CITY OF ALBUQUERQUE

Re: Hastings, 840 Juan Tabo Blvd. NE, (K-22/D035C)
Approval of Permanent Certificate of Occupancy (C.O.)
Engineer's Stamp Date 08-15-2007,
Certification dated 8/31/07

**Re: Hastings at Lomas and Juan Tabo, Grading and Drainage Plan
Engineer's Stamp dated 7-27-06 (K22-D35C)**

**Re: Hastings Grading and Drainage Plan
Engineer's Stamp dated 6-9-06 (K22/D35C)**

LEGAL DESCRIPTION

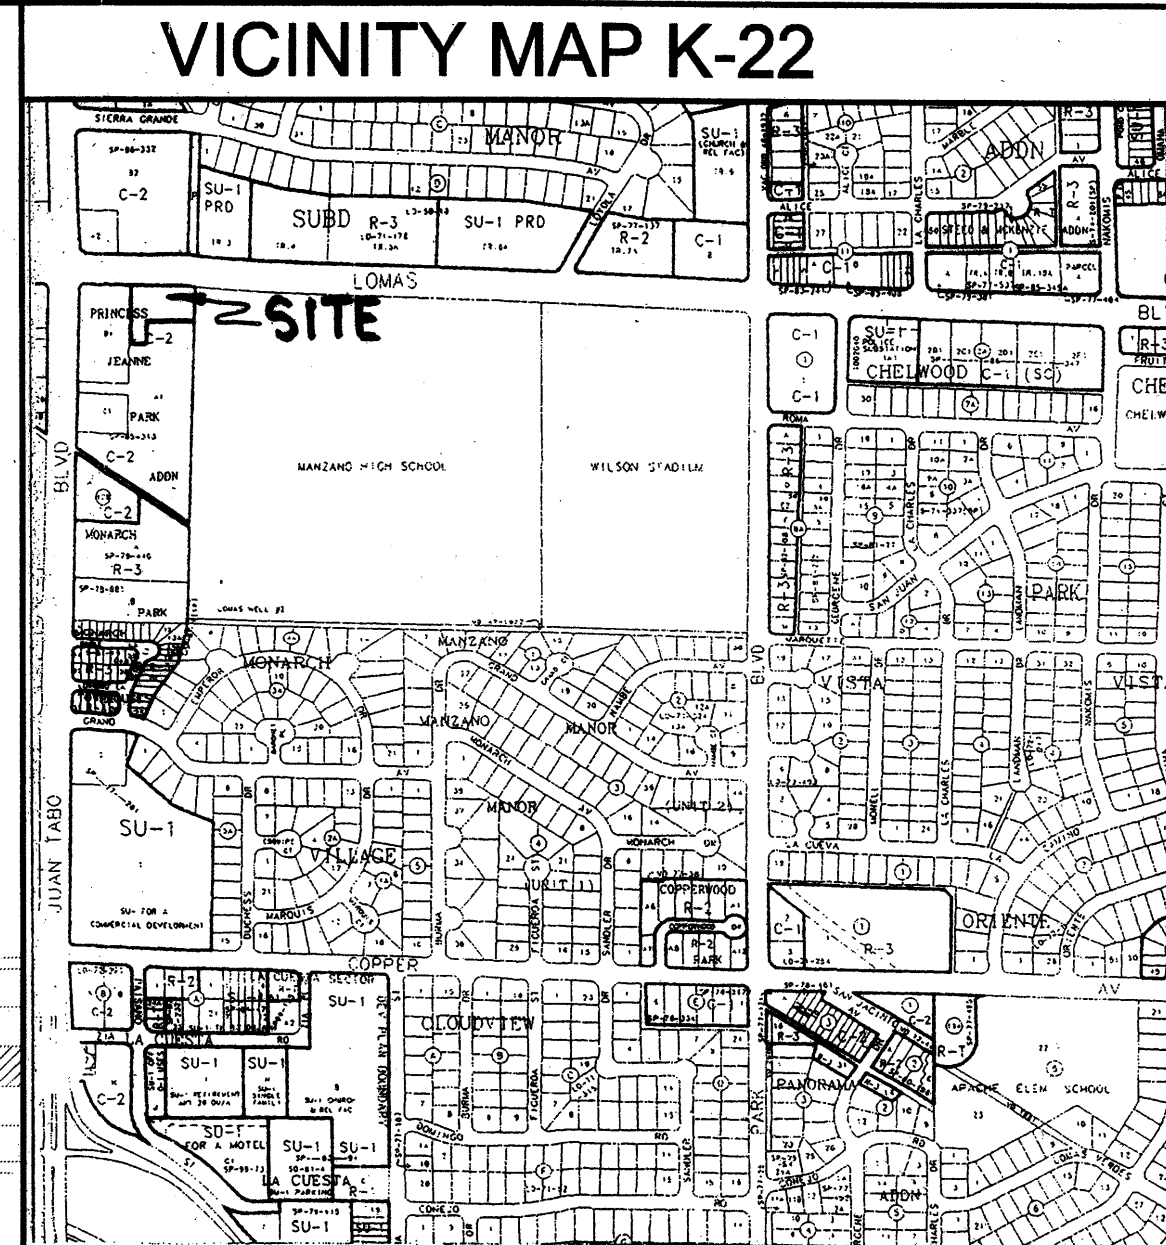
Based upon the information provided in your submittal dated 6-12-06, the above referenced plan cannot be approved for Building Permit until the following comments are addressed:

- Since the finished floor elevation is lower than the street flow line, provide a water block in the drive pad.
- Two spot elevations just west of the drive, 83.65, appear to be typographical errors.
